Your Ref: 2021/94552
Our Ref: Y001832

1st March 2022

Land at Barnsley Road, Denby Dale, Huddersfield – Erection of 53 dwellings and associated works

BARNESLEY ROAD : DENBY DALE | SITE LAYOUT

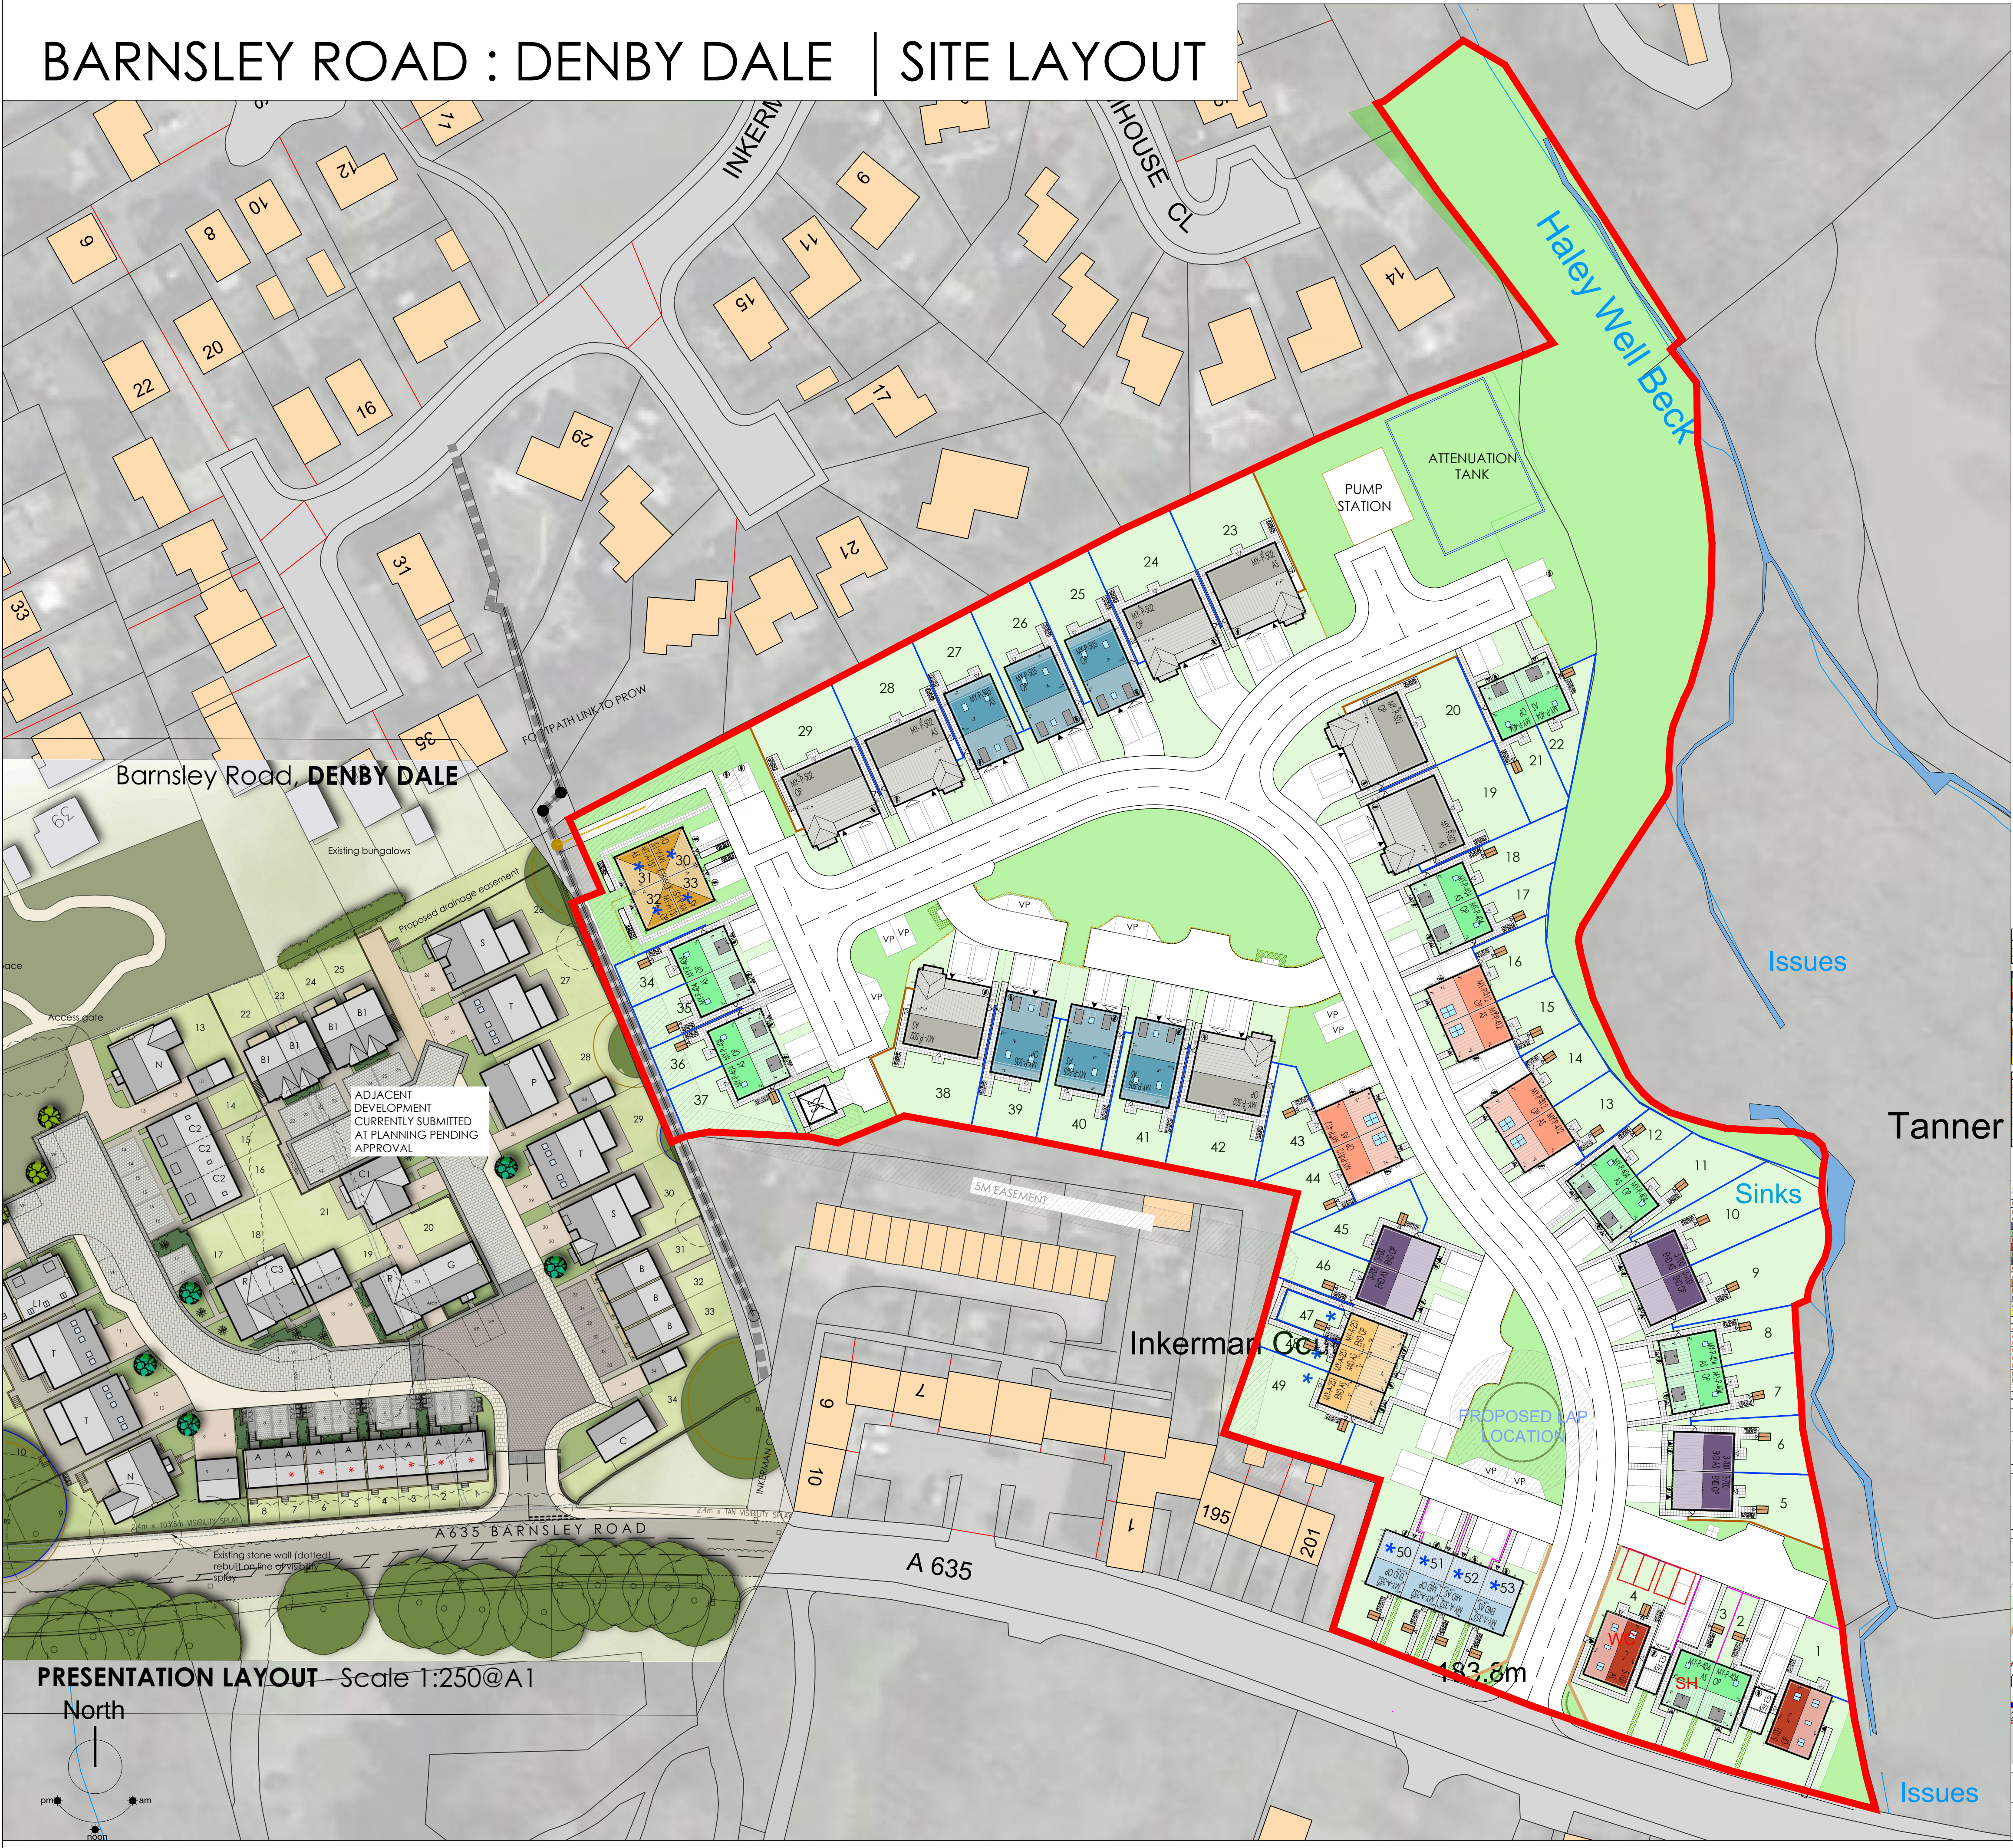
2.) On the Statutory Sewer Map, there is a 225mm diameter public combined water sewer recorded to cross the site. It is essential that the presence of this infrastructure is taken into account in the design of the scheme.

- a.) It may not be acceptable to raise or lower ground levels over the sewer and we will not accept any inspection chambers on the sewer to be built over.
- b.) In this instance, it would appear that the public sewer is unlikely to be affected by building-over proposals.
